DELEGATED ITEM FILE REPORT - REFUSAL

Application No:	3/2014/0122/P
Development Proposed:	Replacement of three existing windows with two second-hand stone mullion windows at Wilkinson's Farmhouse, Simonstone

Drawing Title
**EXISTING AND PROPOSED
EAST FRONT ELEVATION**

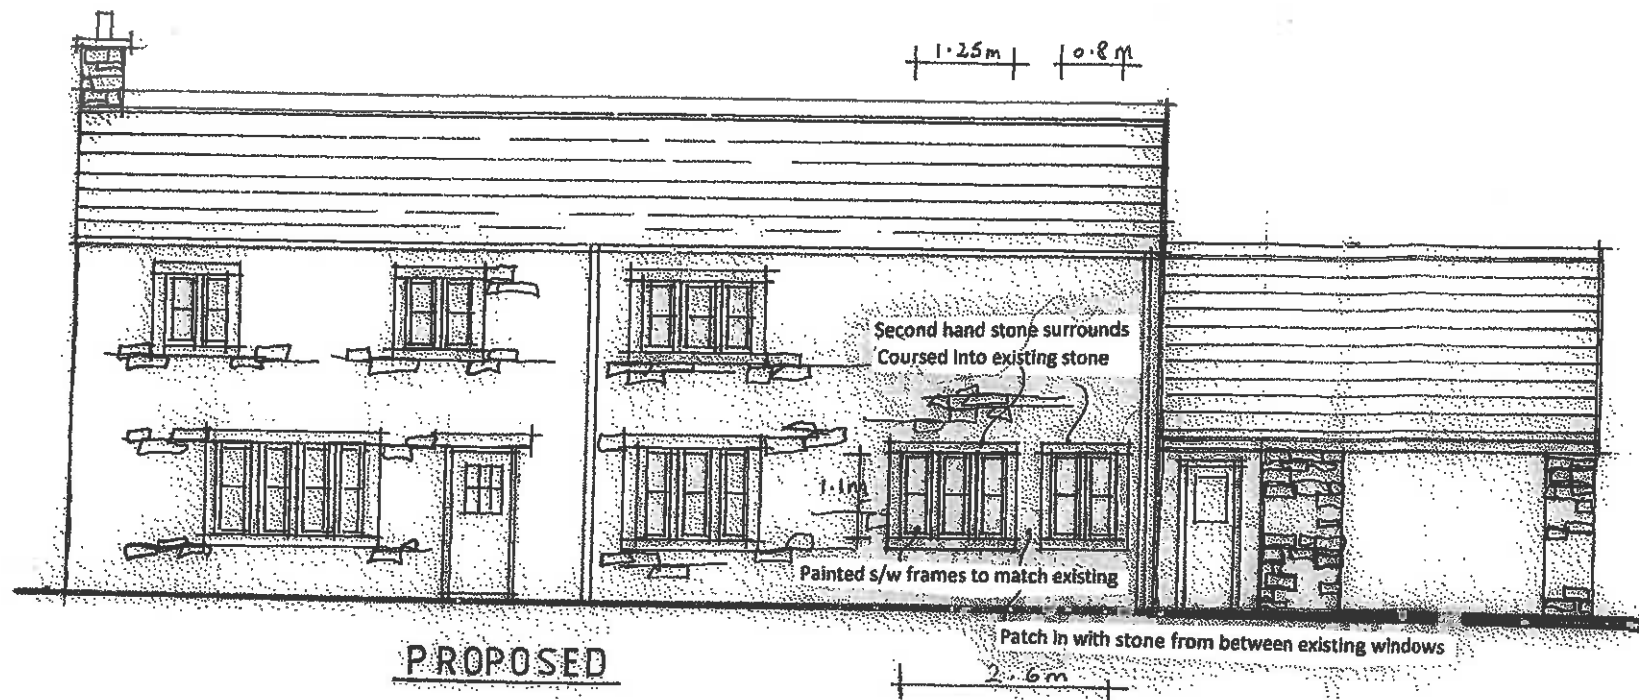
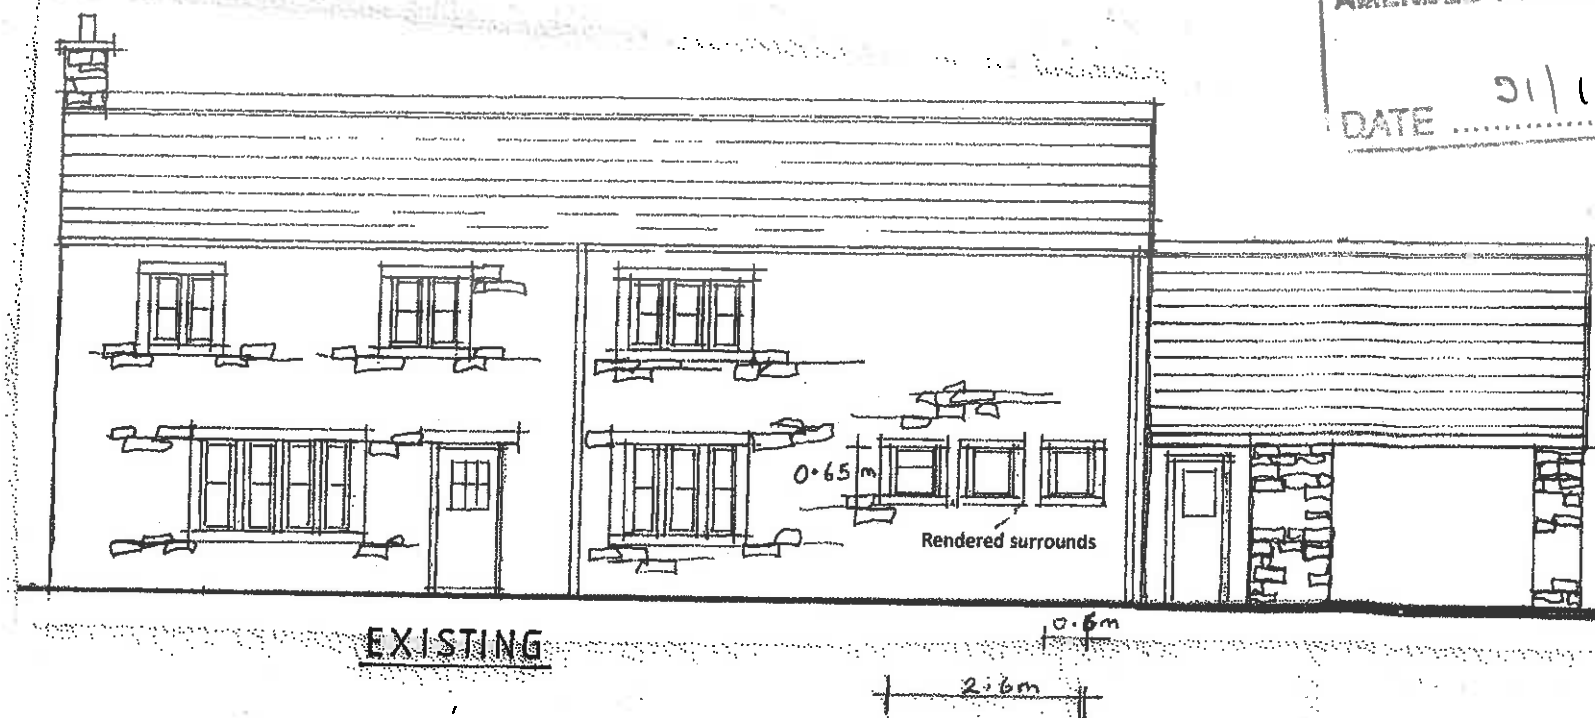
Harmful to character and significance of the listed building and the setting and significance of nearby listed buildings (loss of agricultural identity to bay 3 and the introduction of overtly domestic windows of historical design). NPPF Paragraph 17, 131 and 132; Local Plan Policies ENV20 and ENV19 and Core Strategy Policy DME4.

Little information as to the form of the proposed new window surrounds or glazing has been submitted [section 10(2) Planning (Listed Buildings and Conservation Areas) Act 1990].

In my opinion, the proposals are very harmful to the character of the listed building and the setting of the adjoining listed pigsty/poultry loft.

The third bay of the front elevation retains its historic agricultural character that is distinct from the prestigious mullioned windows of the housebody. Application 7/7/5147 suggests that work was proposed to this section of the front wall. However, the list description suggests this alteration was not undertaken. In any case, I note Paragraph 91 of English Heritage's 'Conservation Principles' that *"authenticity lies in whatever most truthfully reflects and*

HEPPG paragraph 185 is no longer endorsed by Government. However, in this case it is my opinion that "the insertion of new elements such as doors and windows is quite likely to adversely affect the building's significance". The agricultural character of the third bay would be lost and the new windows would confuse the understanding of building history, use and evolution (how the building is 'read'). This compromises the historical and aesthetic value of the building ('Conservation Principles').

In my opinion, the proposals are not sympathetic to the character and appearance of the listed building (Policy ENV20 of the Local Plan) and do not sustain and enhance the significance of the heritage asset or positively contribute to local character and distinctiveness (NPPF paragraph 131).
